Opposing the Epping to Thornleigh Third Track Proposal. Application number SSI 5132.

Name(s): Dawn Irvine

We object to the Epping to Thornleigh Third Track Proposal and consider that the EIS is inadequate and does not address the full impact of this proposal. It will cause untold damage to the health of residents and to the fabric of the Beecroft Cheltenham Heritage Conservation Area. Do not approve this project, reconsider the alternatives and protect the community.

Figure S.6 Cross-section and elevation - New Cheltenham Station concourse building (see also S.5 for artist's impression)

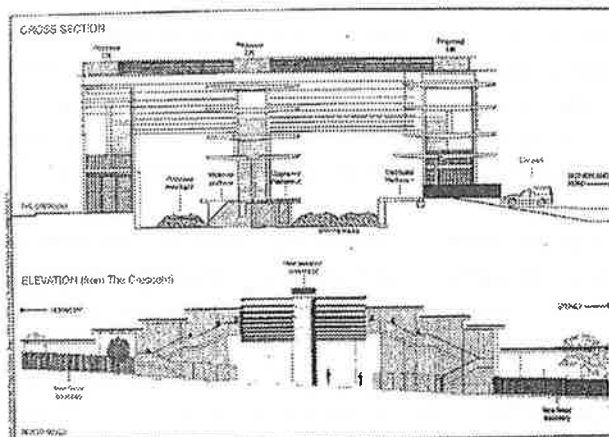
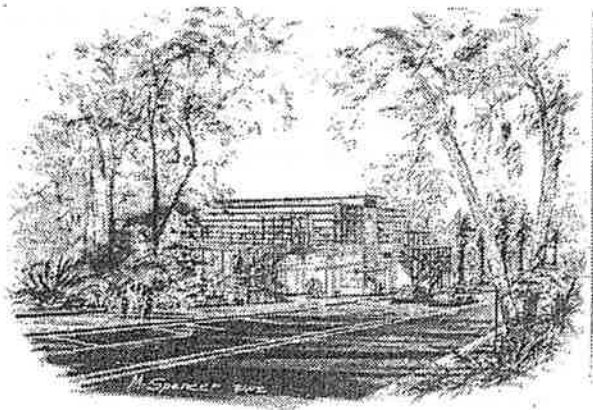
- The proposed redevelopment of Cheltenham Station shows no regard for the HCA. The visual impact of the proposed 13m high glass and steel concourse is totally unacceptable in this HCA.
